Application no: **3/2021/0593**

Address: **Greenbanks Farm Green Lane Grindleton Road Grindleton BB7 4QJ**

Proposal: **Proposed one agricultural building - in lieu of approval 3/2020/0364 which will not be built.**

The Local Highway Authority have viewed the plans and highway related documents and have the following comments to make:

**Proposed Block Plan**  
 DATE 25/04/2020

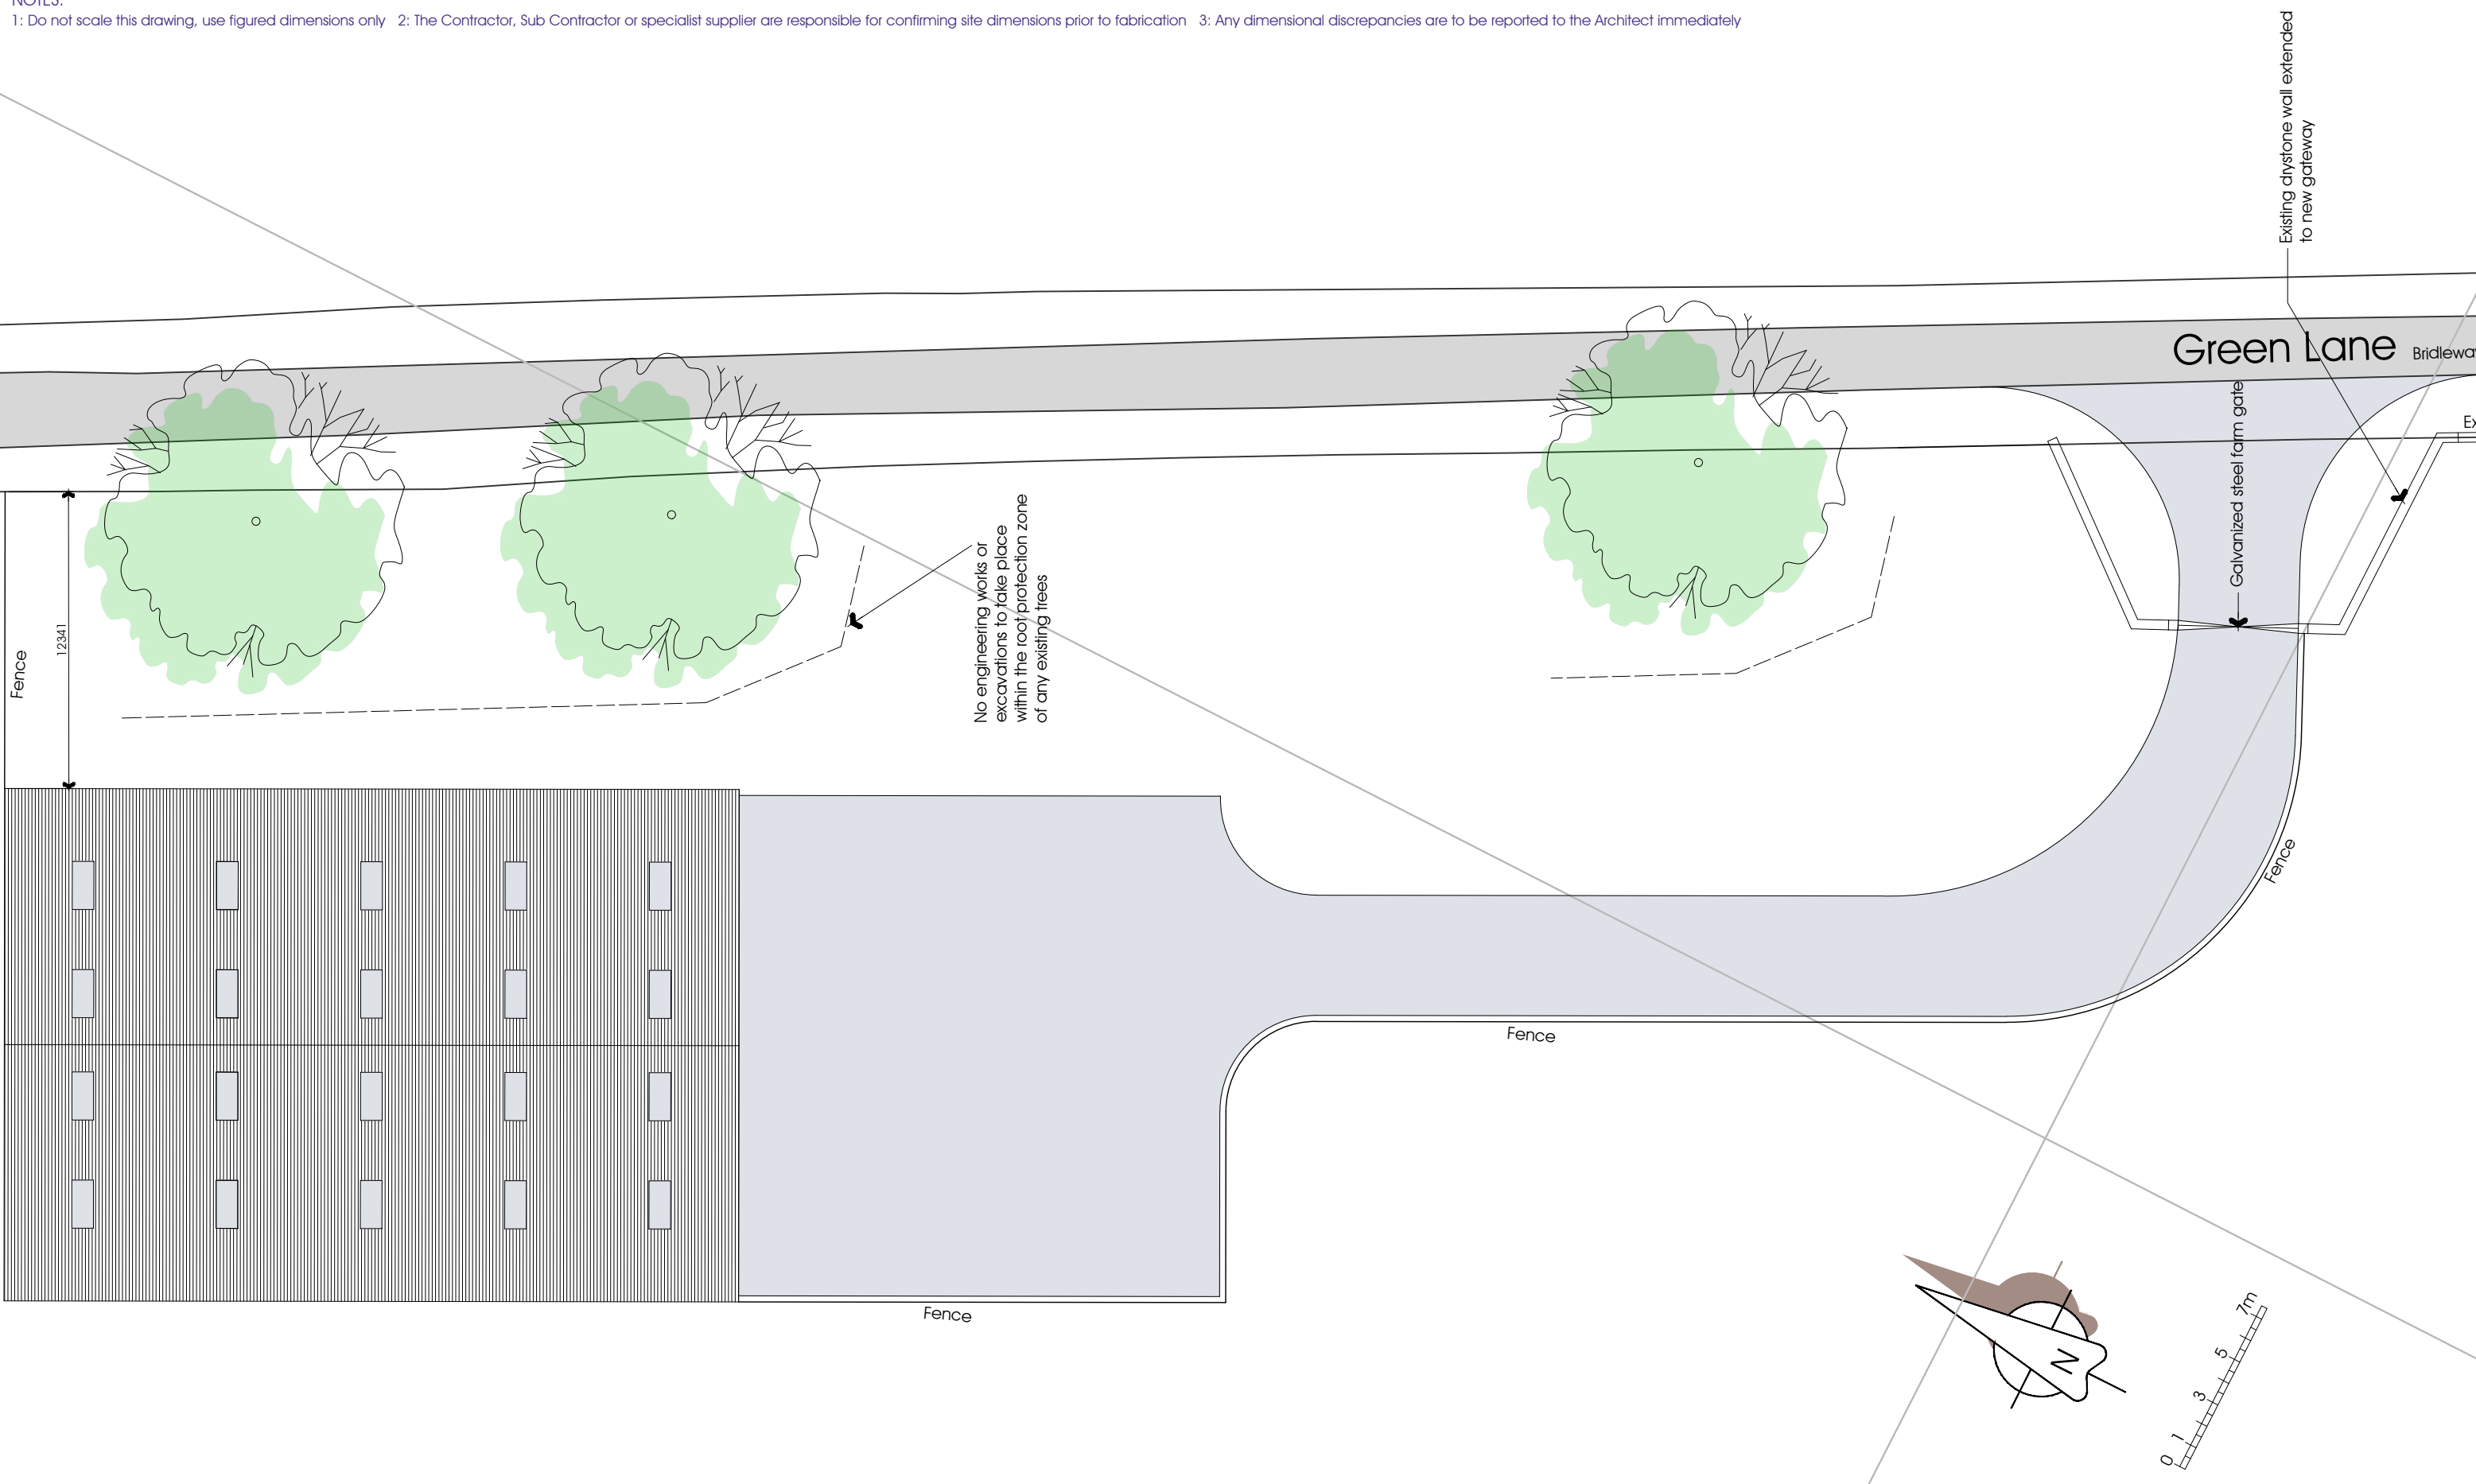
The LHA have reviewed PGB drawing number 003 Rev C titled "Proposed Block Plan," and have no comments to make regarding the proposed internal track, which will be concreted.

The LHA have reviewed PGB drawing number 003 Rev C titled "Proposed Block Plan," and are satisfied that there is suitable space for parking and turning facilities on site which will not obstruct Bridleway BW39. Therefore the LHA have no objection to the application.
